Re: Addison Galaxy FBO Civil Plan Review

Development: Galaxy FBO
Town Project #: 19-09D
Plan Review: 2nd Civil Submittal

Summary of Engineering Review Comments

Date: December 5, 2019
 Plan Review : Civil Review 2
 Received: November 13, 2019
 Plan Date: November 11, 2019
 Development: Galaxy FBO

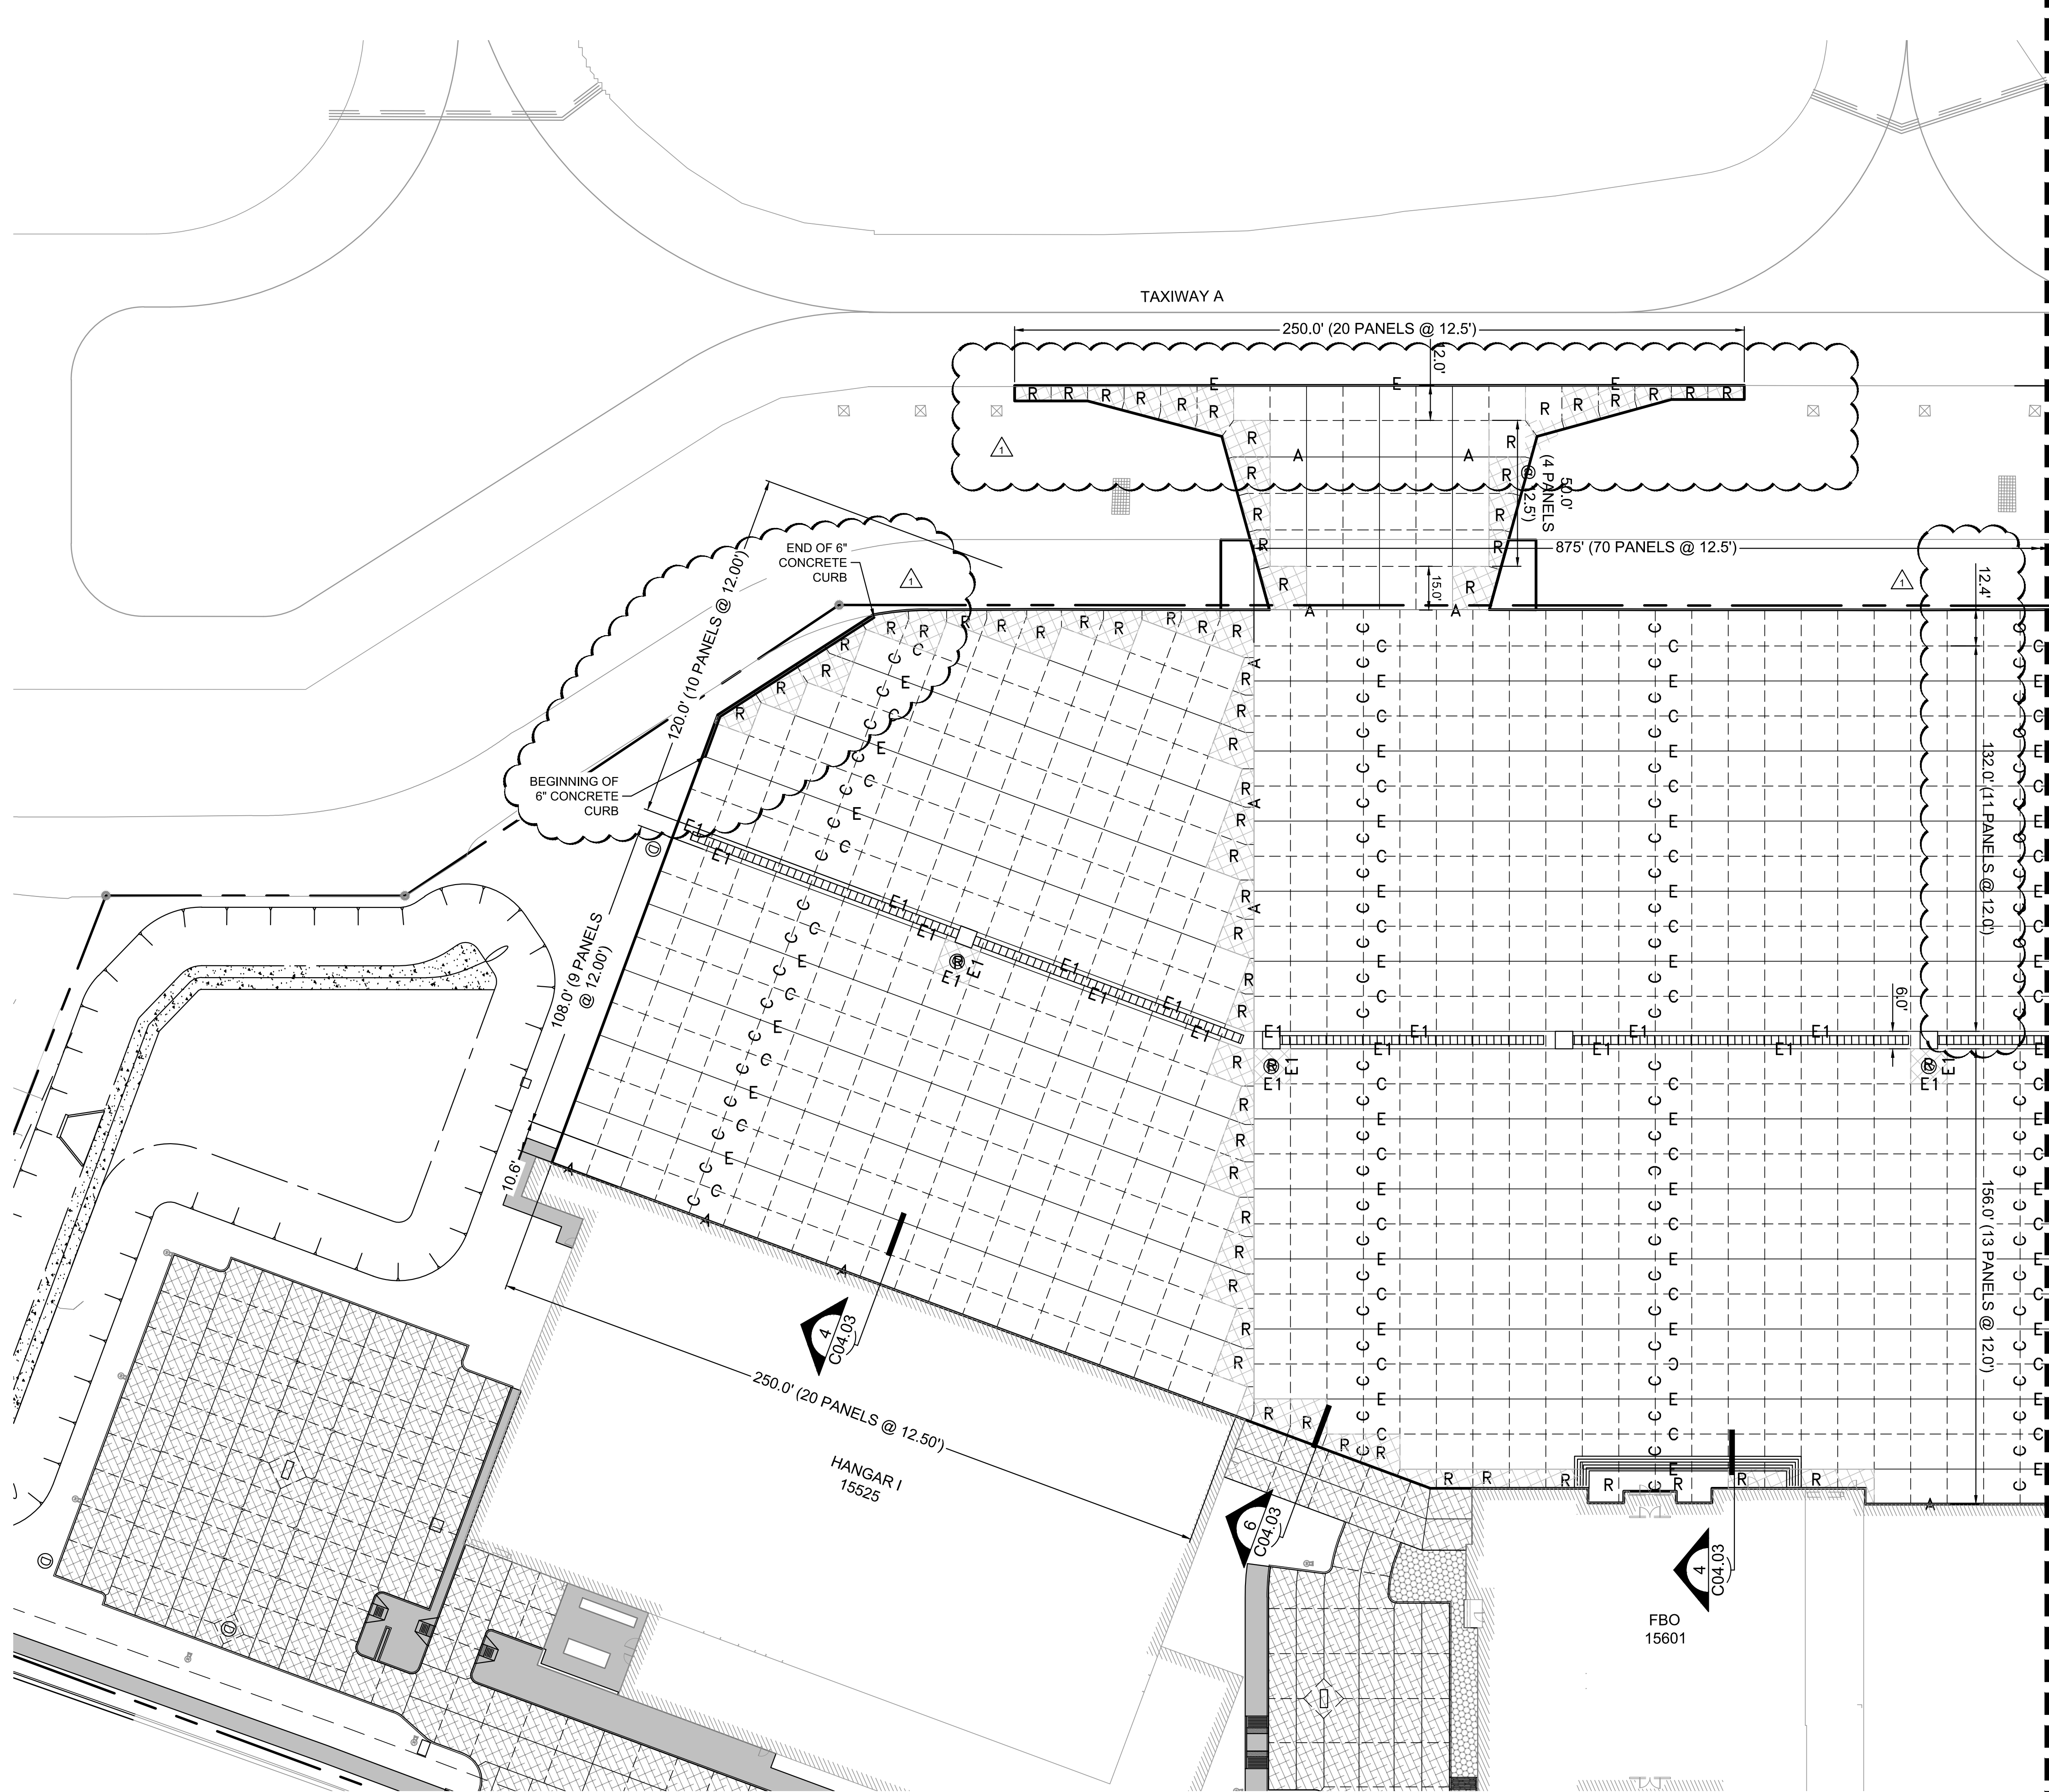
C06.01	Why aren't you squaring off the taxiway approach so can be poured as one continuous piece rather than multiple separate triangles?		
C06.03	Shouldn't Type A1 under detail 2 also be isolation joint?		
DRAINAGE	PREVIOUSLY REQUESTED. Refer to TOA Drainage Criteria Manual for drainage requirements. Reference storm plan requirement checklists (section 5) and required tables & information as shown in the appendix (Fig 11-15)		
DRAINAGE	Use the same naming conventions & stationing for the plan views as in the calculations, for clarity. Storm should be referred to as "Storm Drain" not "Storm Sewer."		
DRAINAGE	Profile all storm lines (not roof drain connections), including laterals.		
DRAINAGE	Indicate type & size of inlets where called out		
DRAINAGE	Identify & label laterals.		
DRAINAGE	PREVIOUSLY REQUESTED. All storm drain within the fire lane should be RCP.		
C11.00, 11.01, & C11.03	Show all offsite drainage areas that interact with the site & include calcs for these subbasins. Account for pass-through flows in your Q100 calculations where appropriate.

SHEET NUMBER  
**C13.02**

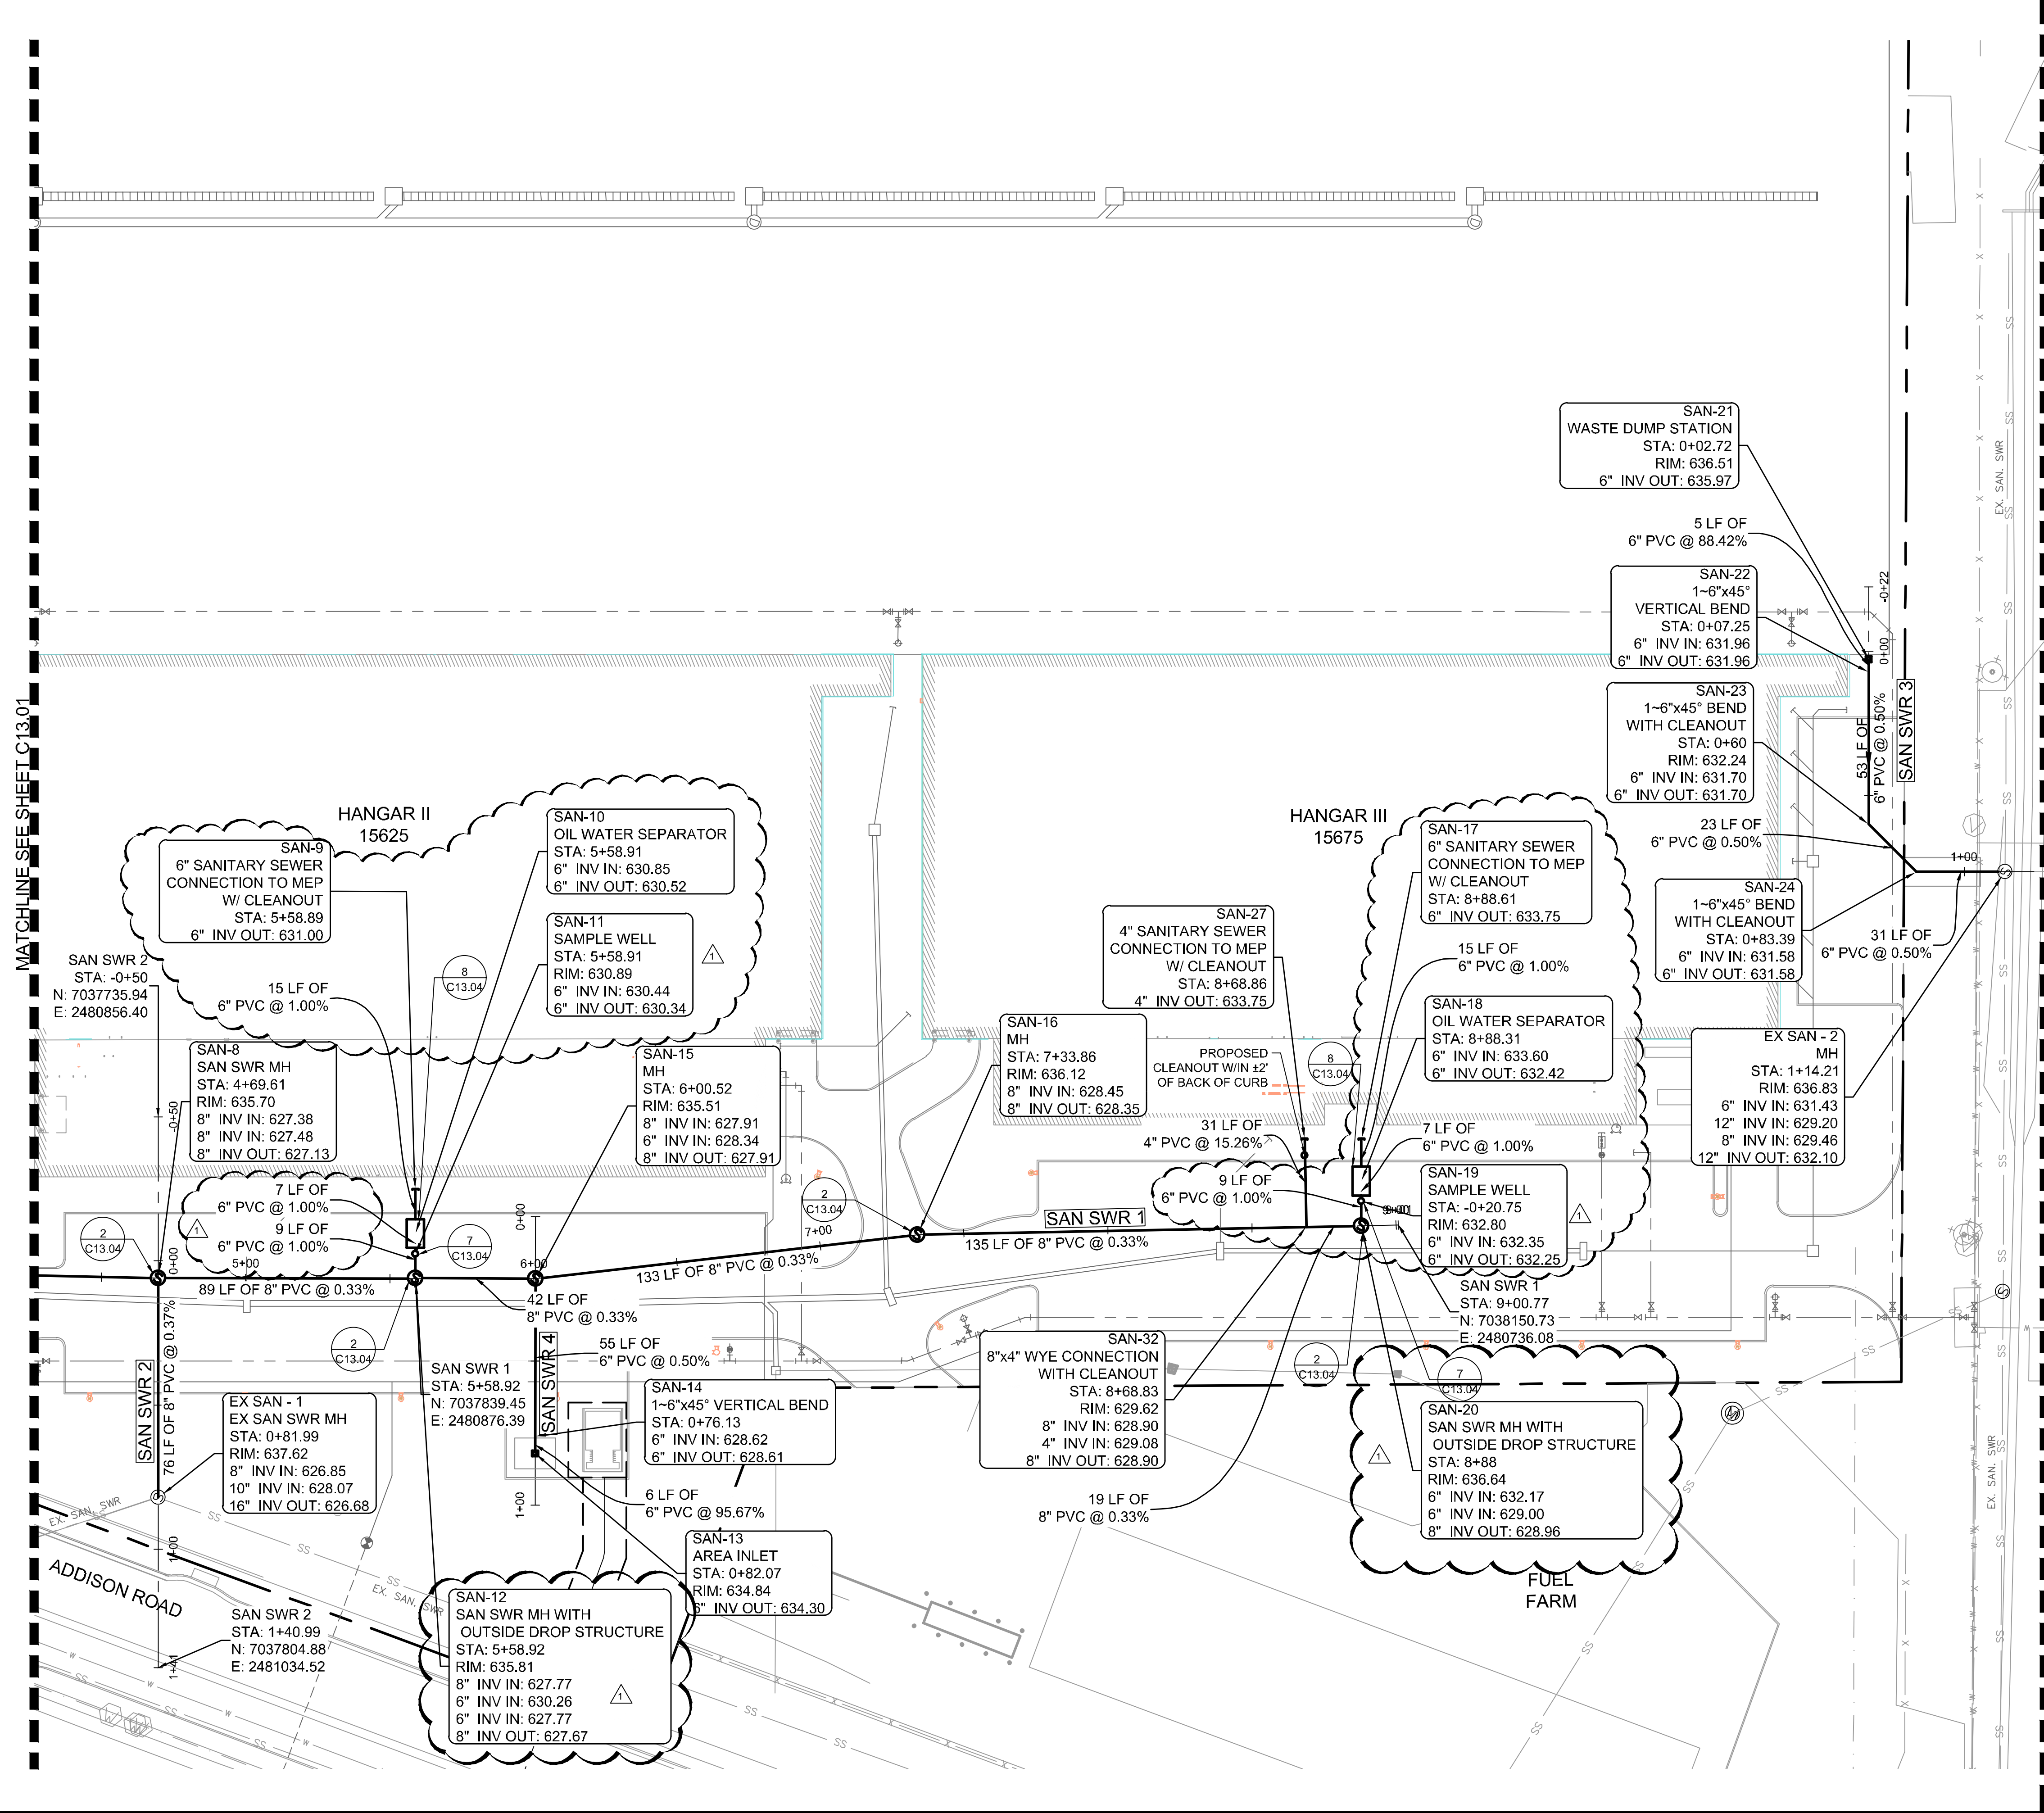
Page No.	Comments	Response (See Note)	Explanation
C12.08	Show all utility service crossings.		
C12.08	PREVIOUSLY REQUESTED. Label HGL100 in profile callouts.		
C12.08	SD-1 : Your HGL100 looks like it's higher than proposed grade in places.		
C12.13	The Addison-specific storm manhole cover is no longer available. Call for a generic "flows to creek" in a note added to the existing standard detail.		
UTILITY	Add embedment notes from plan view sheets to profile sheets as well.		
SANITARY	Add civil cleanouts at the back of curb on all services & include TOA standard cleanout detail.		
SANITARY	PREVIOUSLY REQUESTED. Legend - why calling for a clamp?		
C13.01	Show 90bend on the the sanitary service out of Hangar 1 to indicate it will not cross the water services.		
C13.01	Why are you calling for DI on the 4"?		
C13.01	SAN-25 doesn't have a station in the callout		
C13.02	Identify SS-4 in plan view		
C13.02	SAN-32 : check invert elevations

C13.02	SAN-24 : add w/ cleanout		
C13.04	PREVIOUSLY REQUESTED. TOA has new batch of MH covers that reflect the "new" logo. note that these should be procured from public works. <i>This detail was stapled to the sanitary sewer detail sheet markups provided after Civil Review 1. They were still attached to the markup set when you returned it with the Review 2 submittal. It has been attached again for your use.</i>		
WATER	PREVIOUSLY REQUESTED. Add valves as noted in the markups & water system requirements (valve on each leg of a tee unless in close proximity to another valve on the same line - deletion of a valve is at staff discretion). <i>Valves on each leg of a tee is a Town of Addison water system requirement and you must comply unless Town staff indicates that a specific location does not need one. Add all valves as requested.</i>		
WATER	PREVIOUSLY REQUESTED. Show & label all applicable vaults & BPA's (must be outside of vehicular surfaces). <i>BPA's are not shown.</i>
